To the Examiner Stuart Cowperthwaite

Friends of Markeaton Park notes that Highways England submitted responses to our submissions for deadlines fourteen and fifteen.

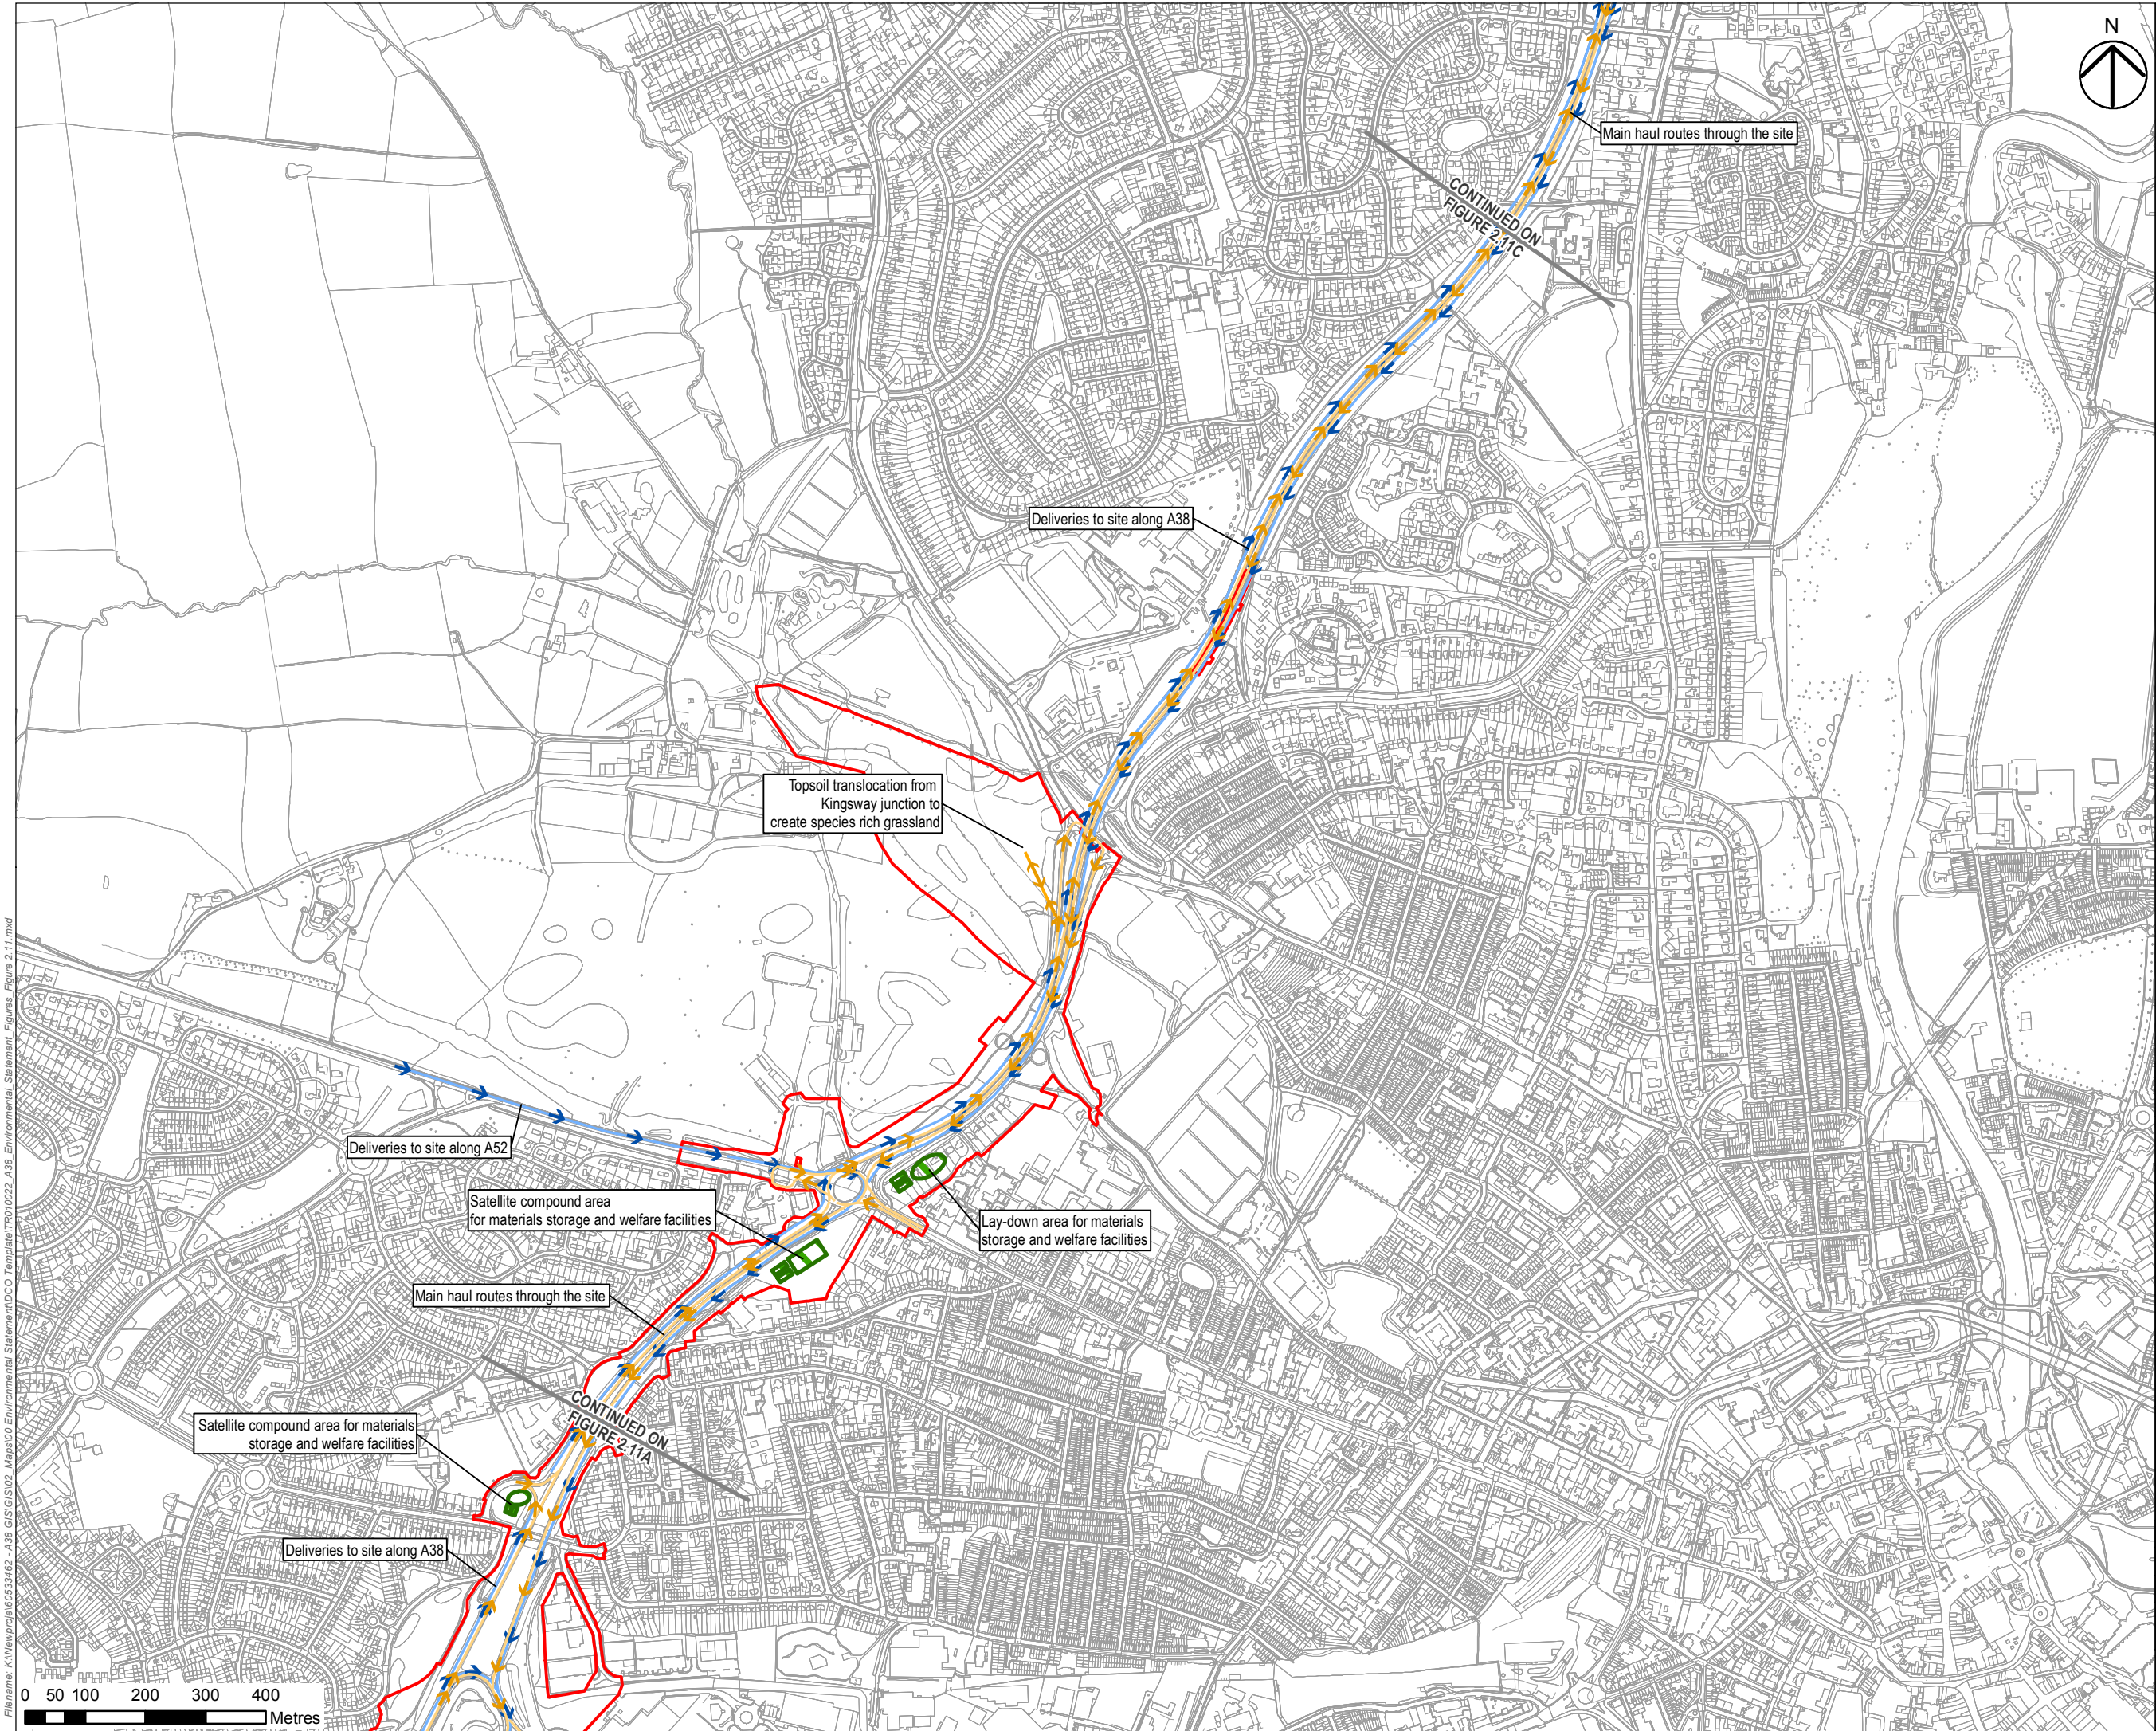
Highways England information	Friends of Markeaton Park questions
<p>FOMP How many lorry-loads each day, for how many days?</p> <p>It is estimated that approximately 840m<sup>3</sup> of soils will be translocated from the LWS to Markeaton Park. Such a volume of material would require approximately 84 haulage trips. It is anticipated that material haulage could be completed in less than two weeks.</p> <p>FOMP Will the receiving area be cleared and re-profiled before the translocation begins?</p> <p>An equivalent volume of topsoil will be removed from the Markeaton Park receptor site prior to the trans-location (comprising an area of amenity grassland with no trees). Following completion of the works, the site profile will be similar to existing levels.</p> <p>Highways England is not sure what point FOMP is making with the screenshots.</p>	<p>Where will the 840m<sup>3</sup> of soil removed from Markeaton Park be taken?</p> <p>Doesn't exchanging the A38 soil for Markeaton Park soil increase the Carbon footprint?</p> <p>Derby City Parks department had plans. Does soil change hinder those plans?</p> <p>If the Local Authorities, Natural England, Environment Agency and Environment Charities had the same legal and financial resources as Highways England would they oppose these manoeuvres?</p> <p>The first two screenshots for deadline 15 illustrated the difficulty of digging a utility corridor between the edge of the road and the retained vegetation. <i>Where will the diggers and lorries collecting the soil be? Where will the lorries carrying the specialist sewage, clean water, gas, communication, and electric apparatus wait? On the roots protection area of the retained vegetation?</i></p> <p>The third screenshot contrasted the reality of the operation with the claims Highways England make to justify it.</p> <p>The fourth screenshot shows the wide damage the 3 junction scheme does to biodiversity, losing hedges and trees. True relocation would place waterside soil adjacent to water and plants in correct orientation.</p>

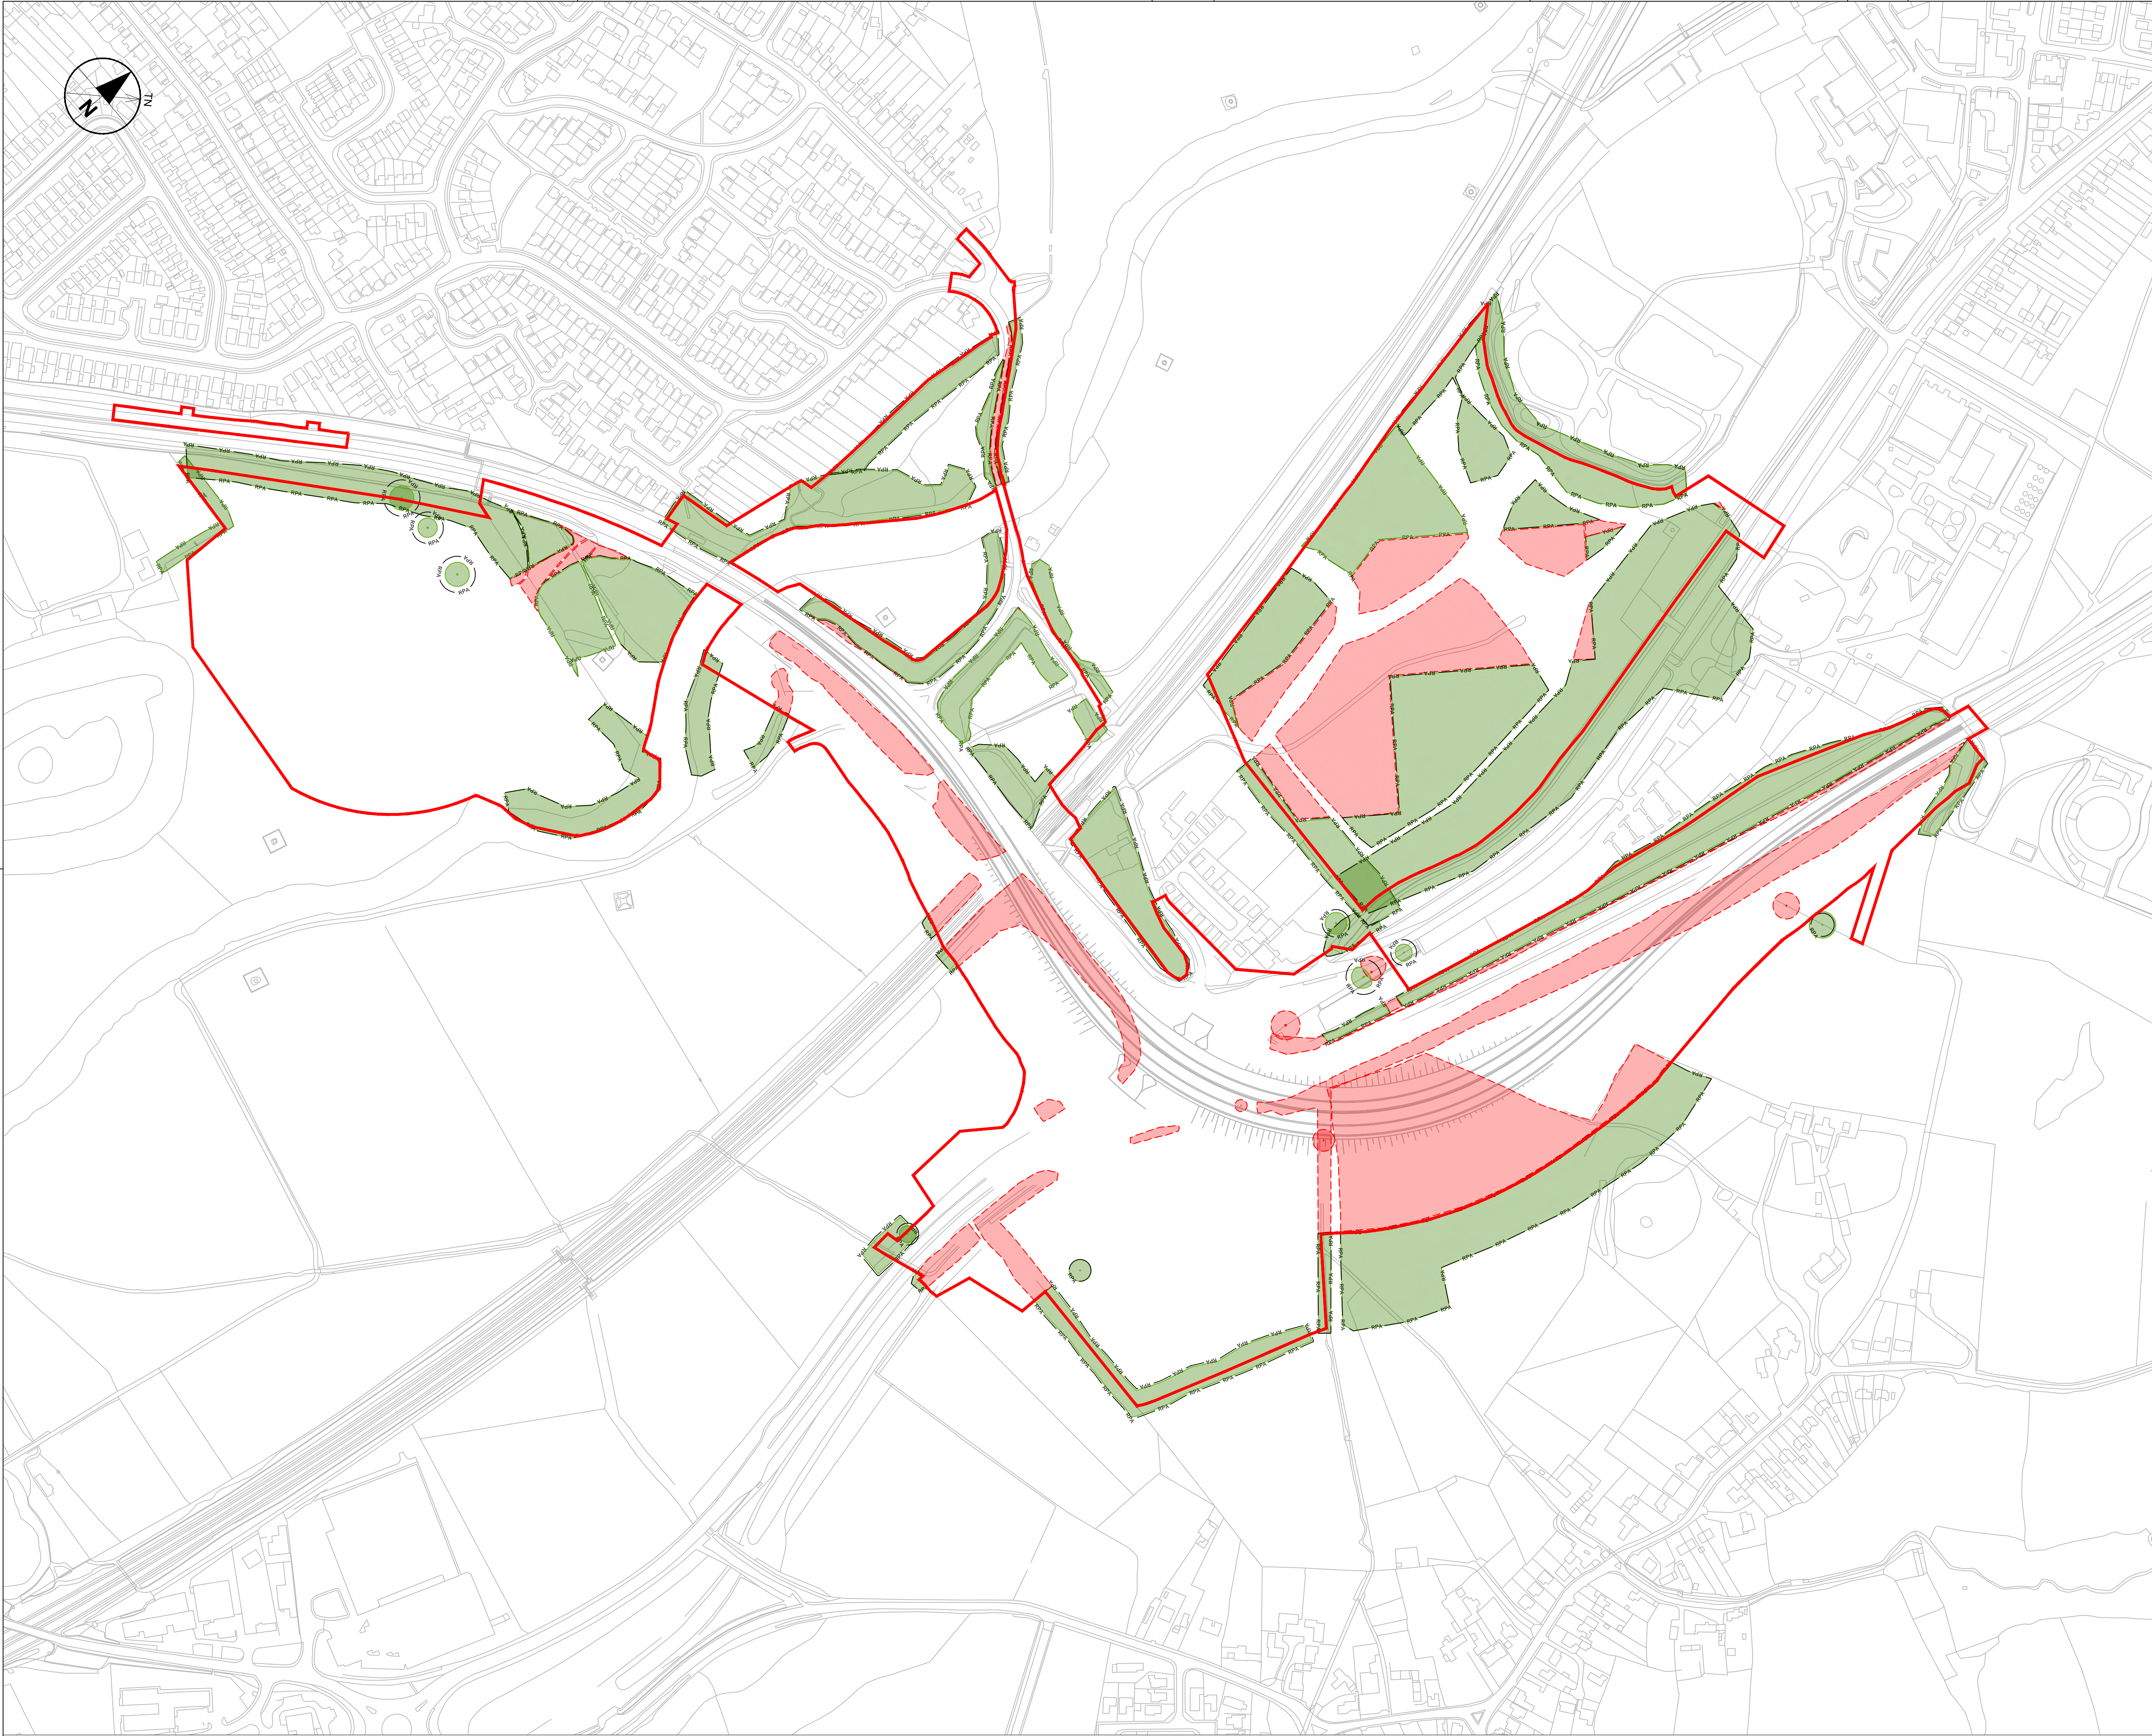
The Chief Planning Officer of Derby City Council, who spends his working life studying plans, lamented that “it is extremely difficult to get information” as Highways England ignored outright questions about the number of trees to be lost and the ratio of replacement mitigation.
